Our Ref: CM/27/18/PL
Your Ref:

Town & Country Planning Act 1990 (as amended)
Town and Country Planning (Development Management Procedure) (England) Order 2015
Application for Planning Permission

Development Change of Use to A1 Retail
Location Bairds Farm Shop Crookthorn Lane Climping

PLAN 3

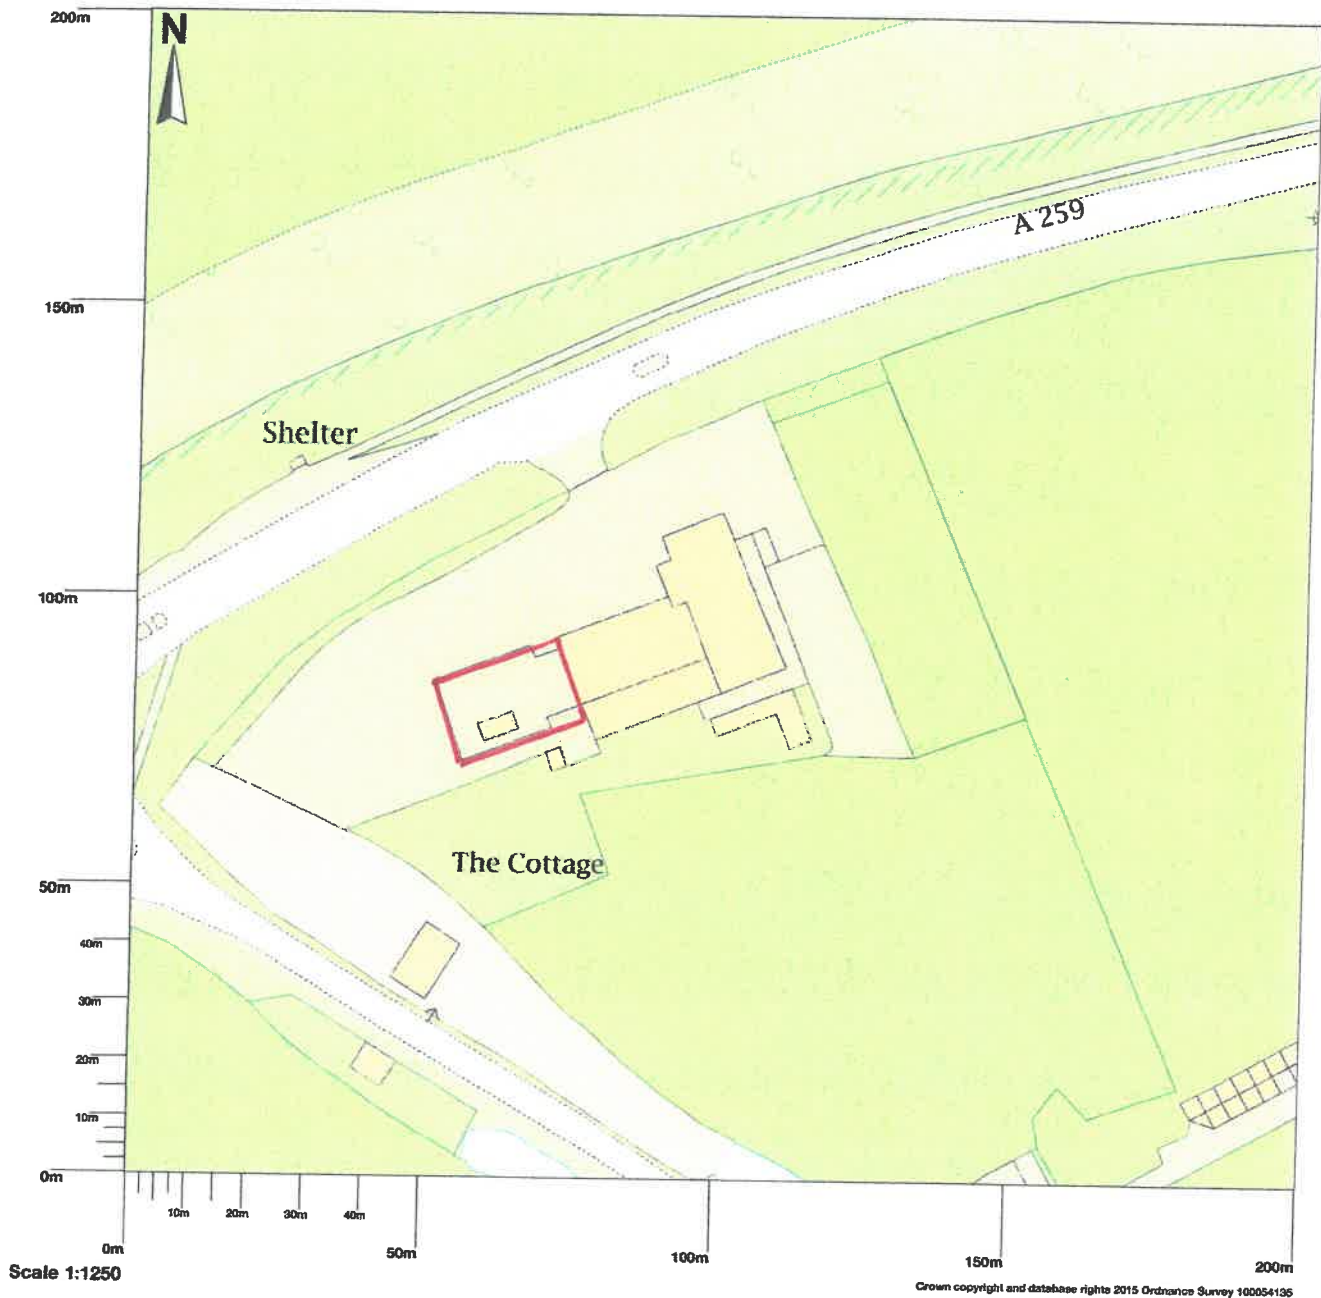
Plan 2 & 3 do not have a scale. Please forward scaled drawings.

PLAN 1. BAIRD'S FARM SHOP DEMISE.

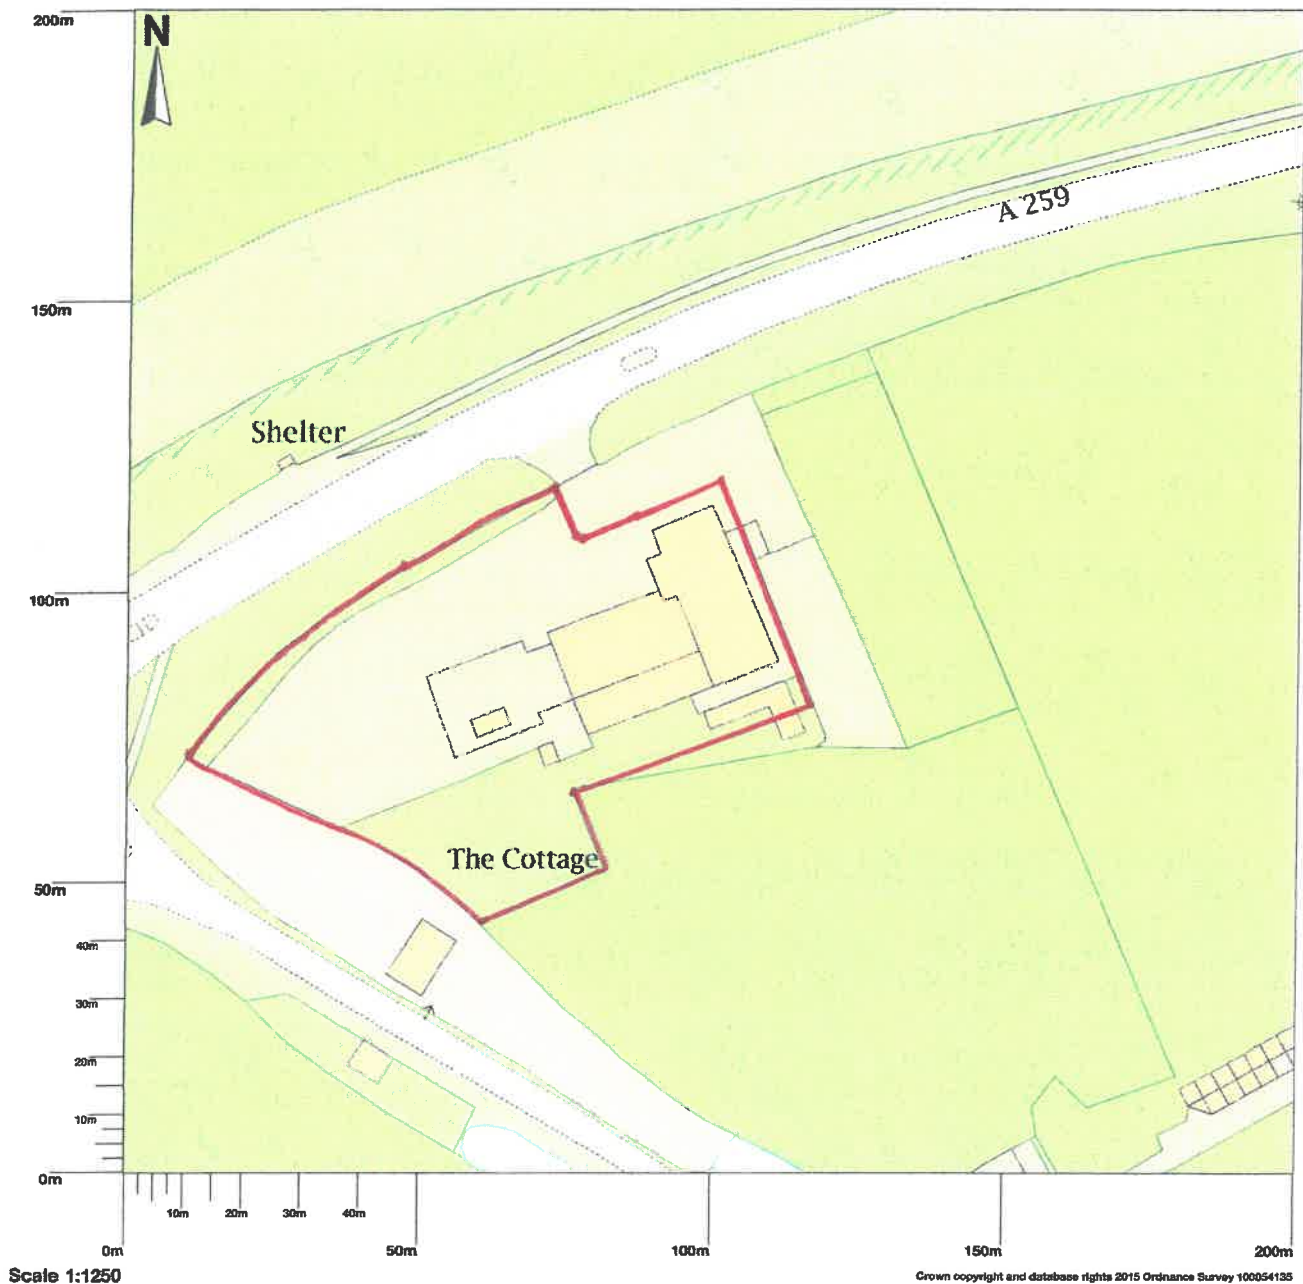
Plan 01 Rev 01 has been uploaded as an A4 plan and is therefore not scaling. Should this be part of the application as we have also received a Plan 01 Rev 5?
